RE: Notice of Modification, Redevelopment of Parramatta Public and Arthur Phillip High Schools, 80-100 & 175 Macquarie Street, Parramatta, (SSD 7237 MOD 5)

Responses to City of Parramatta Council Letter, dated 3 September 2019, ref NCA/1/2016

Figure 1: Indicative Staging Plan

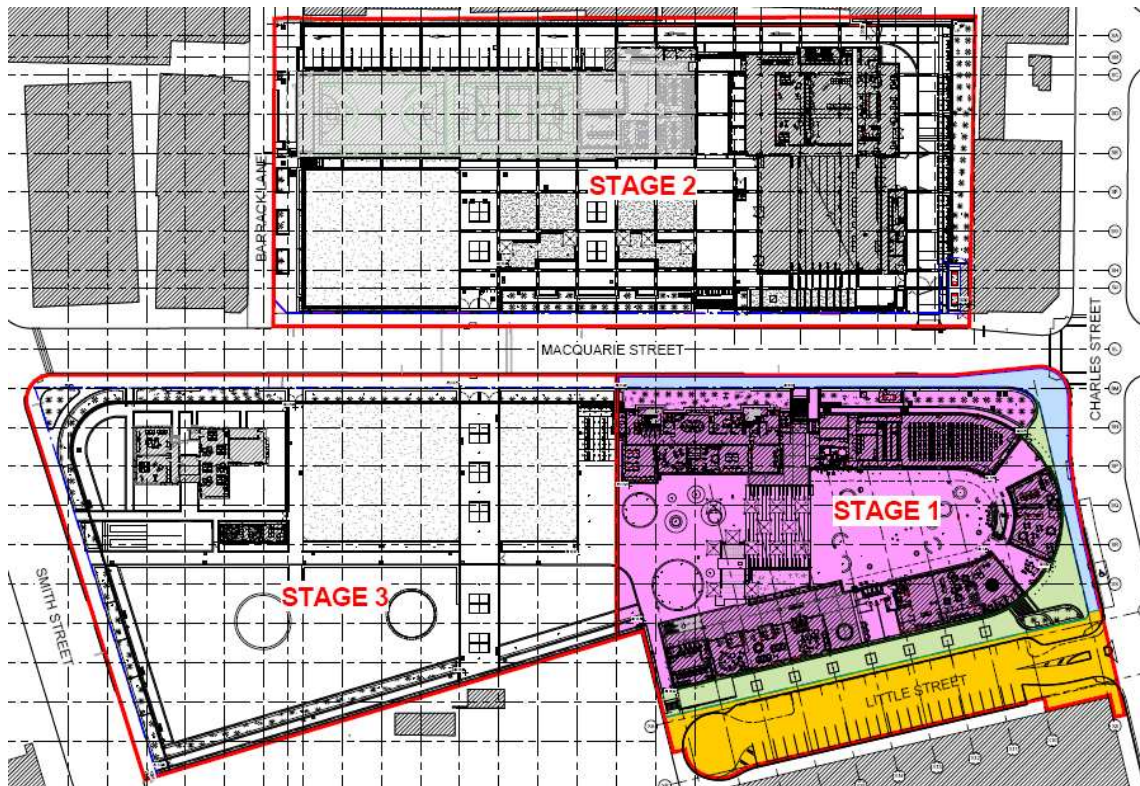
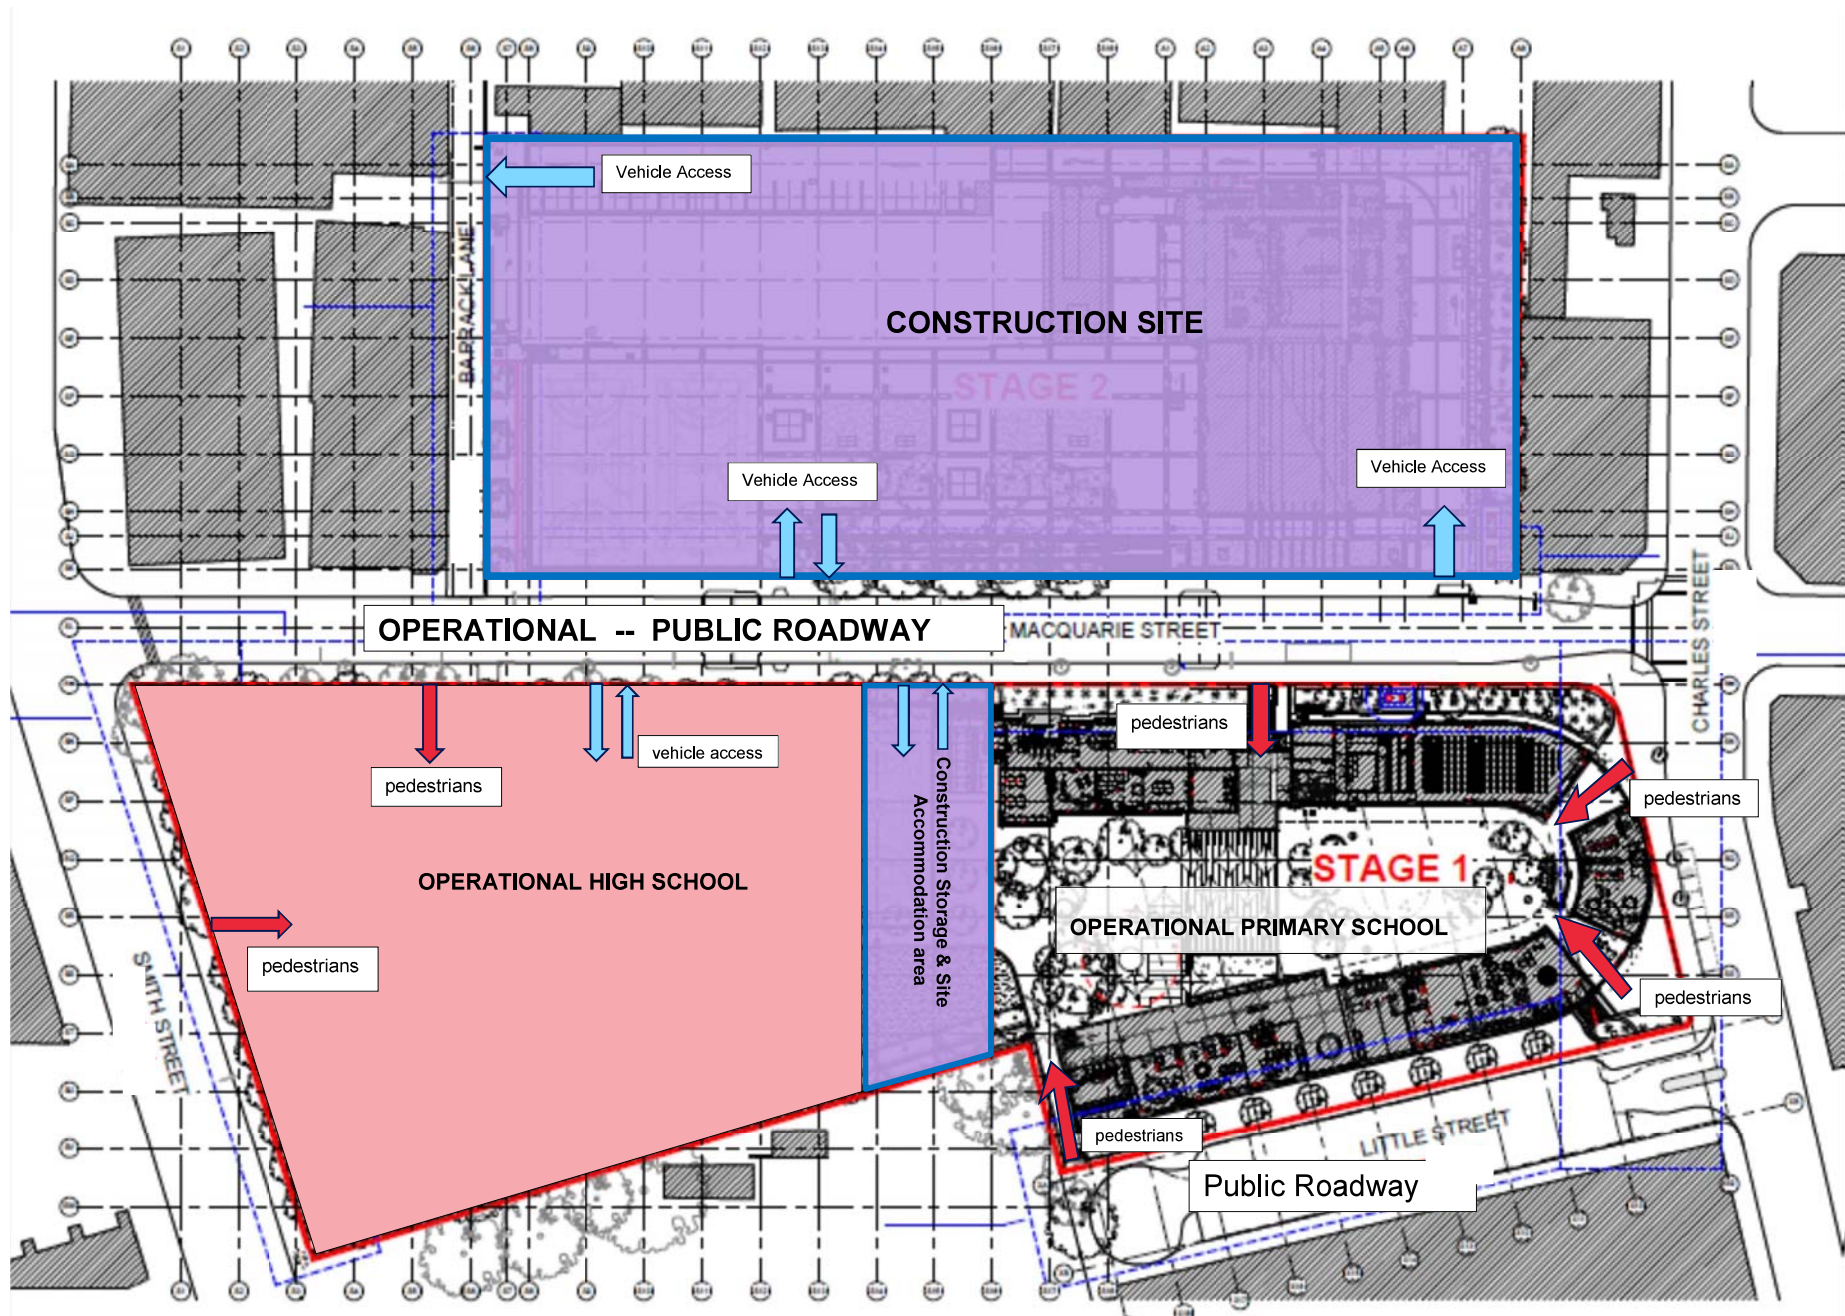
SINSW ID.	Ref	Comment	Response
	A. MODIFICATION REPORT		
1	Section 2.3 New Condition Paragraph 1	It is noted that the indicative staging plan submitted with the application does not clearly indicate the property boundaries and stage boundaries. The stage boundaries should clearly indicate the areas of public domain.	The indicative staging plan has been amended to clearly demonstrate the property boundaries and stage boundaries associated with the application.
2	Section 2.3 New Condition Paragraph 2	Stage 4 should include all the final public domain works for Macquarie Street and Barrack lane. No other roads should be indicated as Stage 4 (contrary to the indicative staging plan shown).	Refer to drawing no. AR-SI-A08-154, named Indicative Staging Plan – Stage 4. This plan has been included in the Staging Report to clearly demonstrate the final public domain works for Stage 4, which relate to the final public domain works to Macquarie Street.

B. STAGING REPORT			
10	Staging Plan – Bullet Point 1	Attachment 1 – the Staging Plan should clearly indicate the areas of public domain included within each stage.	The indicative staging plan has been amended to clearly demonstrate the property boundaries and stage boundaries associated with the application.
11	Staging Plan – Bullet Point 2	The entirety of Little Street should be included in Stage 1 (with allowances for timing of delivery)	Since the submission of the Modification Application, the final agreed Kiss and Drop zone on Little Street has been approved by Parramatta City Council. The Staging Plan has been updated to highlight Little Street as part of Stage 1.
12	Staging Plan – Bullet Point 3	Stage 4 should include all final public domain works Macquarie Street and Barrack Lane only.	The proposed Stage 4 works have been updated to relate to Macquarie Street only. No public domain works are proposed to Barrack Lane.
